# Planning and Urban Development Department

**Subject:** B-2c Design Review – 72 Bishop Street  
**Written by:** Caitlin Cameron, Urban Designer  
**Date of Review:** Monday, June 29, 2015

Sheet No.: **L2**

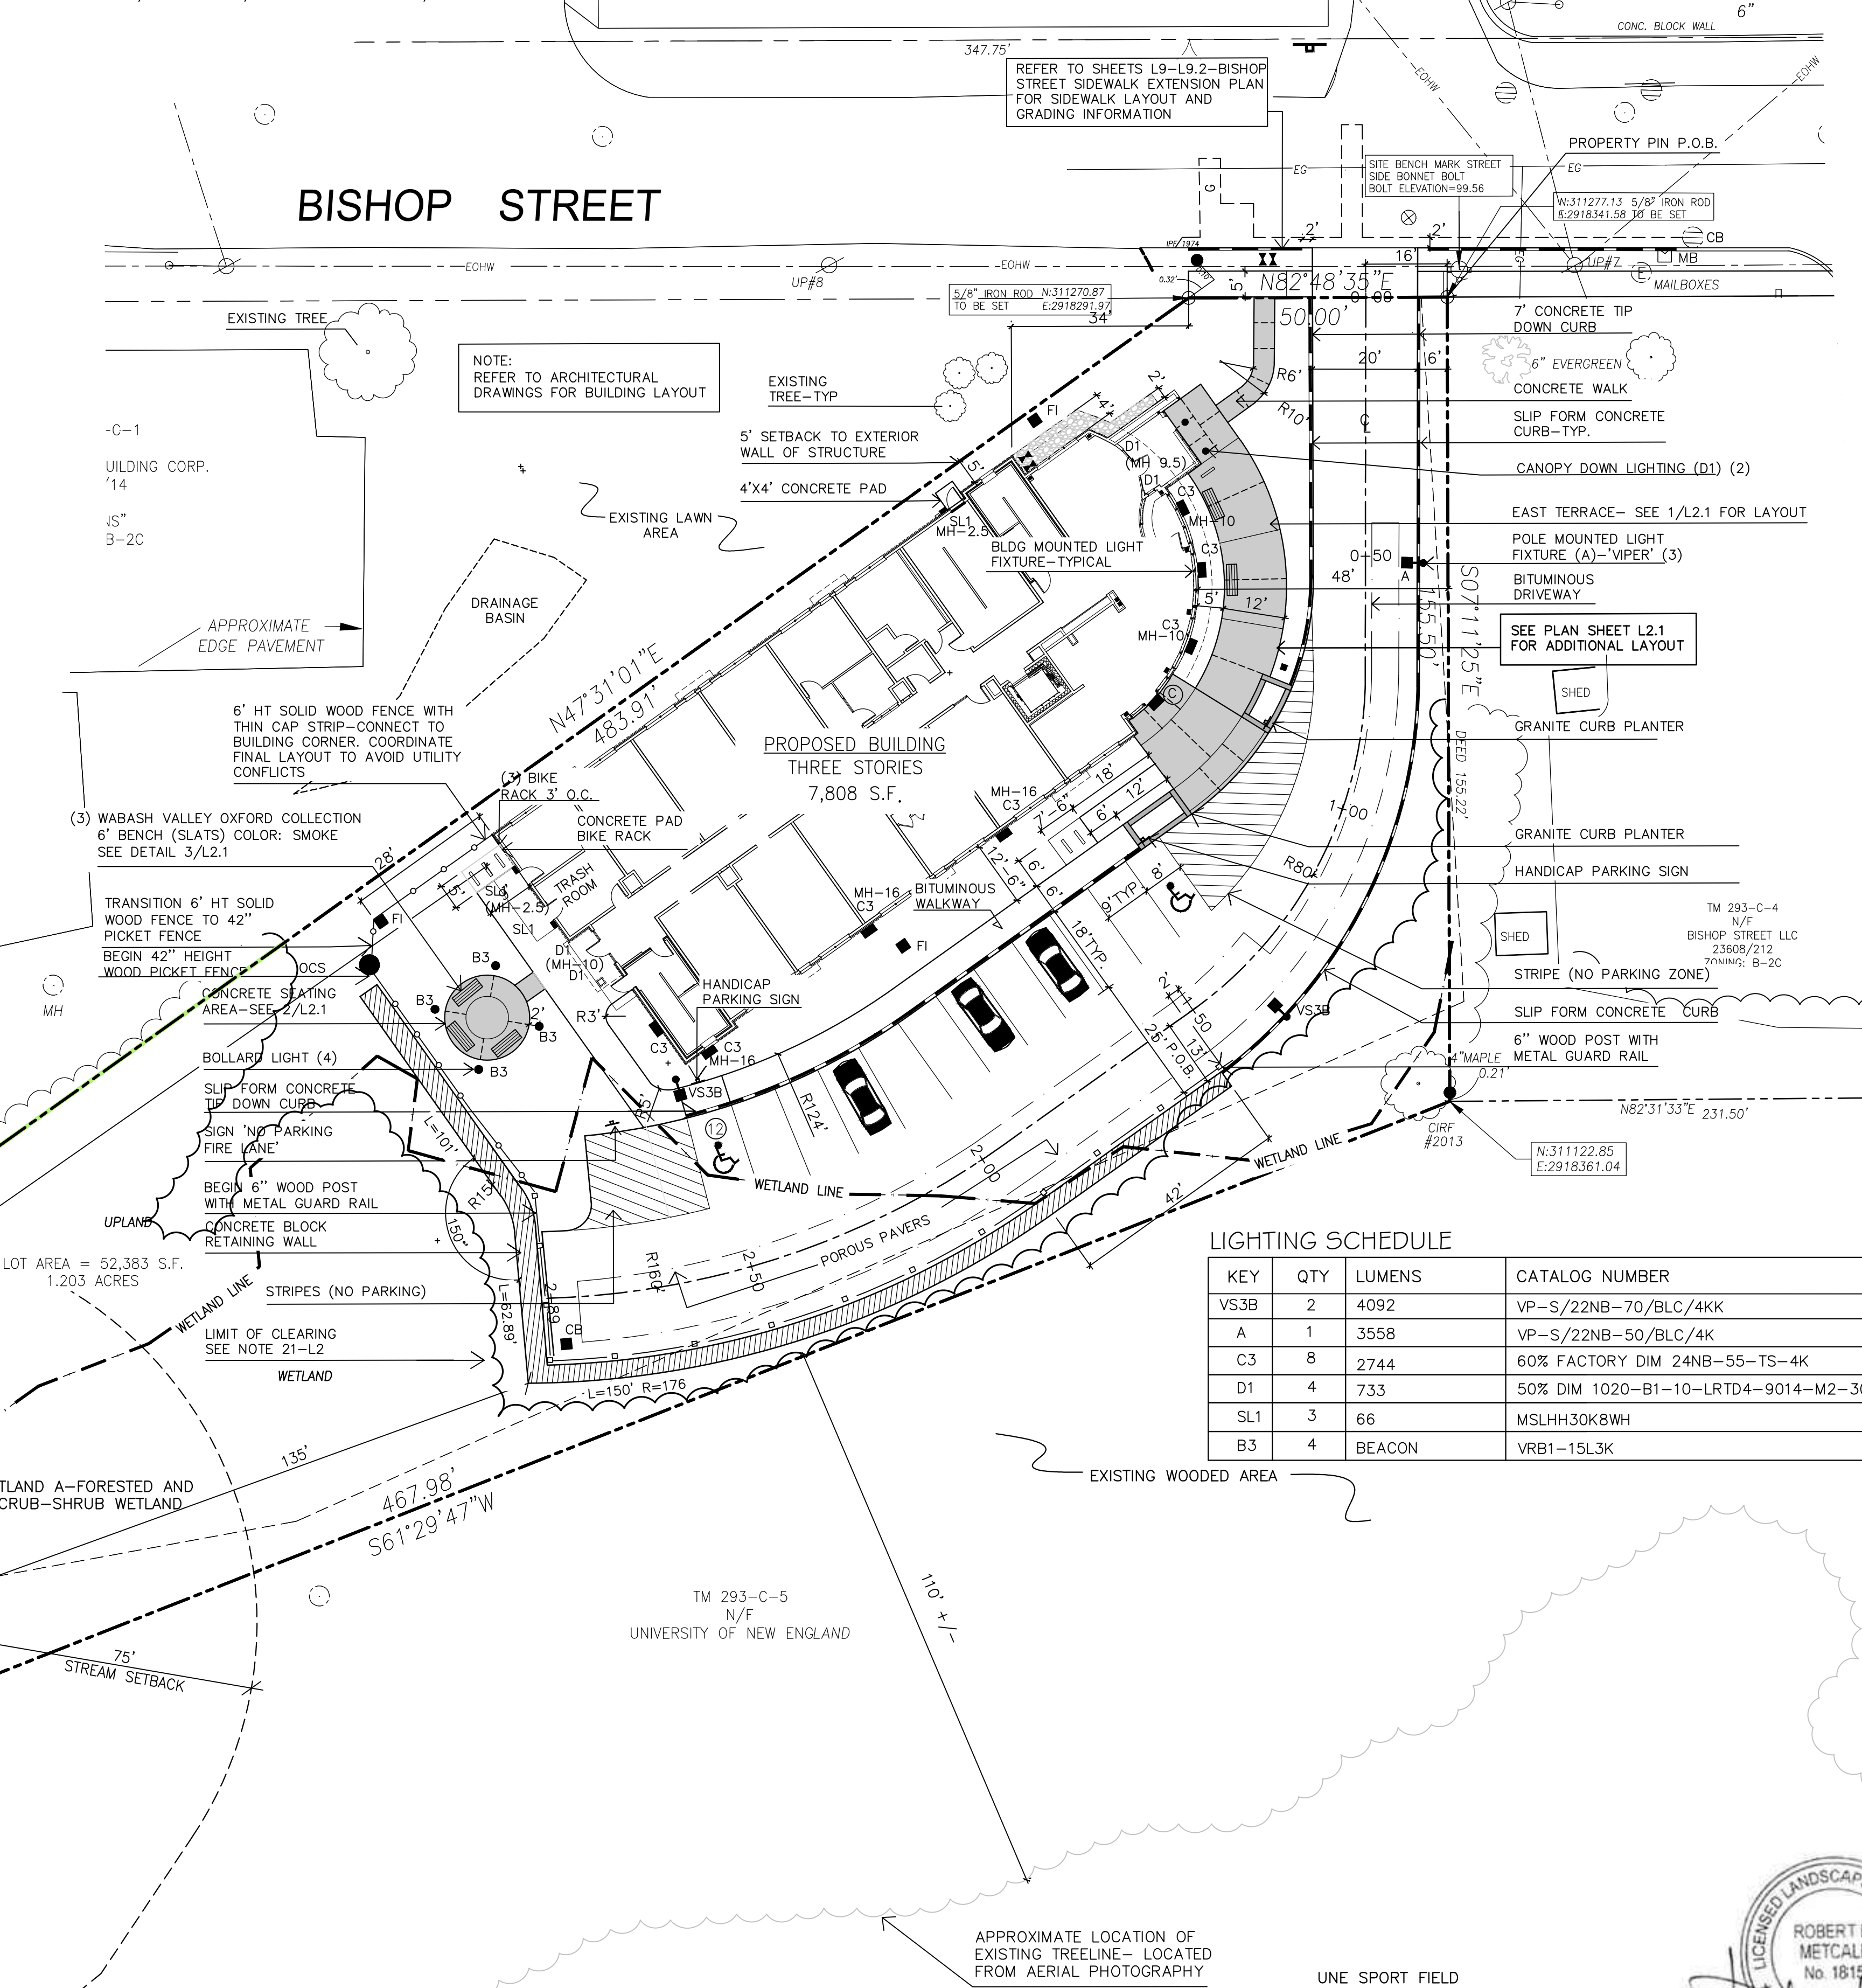
*Standard 3* – The project provides a garden space and screening and landscaping elements as required by the Standard. The outdoor seating area is screened from neighboring parking lots with a 6' solid wood fence. A 42" wood picket fence separates the wetland area from the seating area. Consider providing additional landscaping/screening to the Northwest property line to buffer dwelling units from the neighboring parking lots.
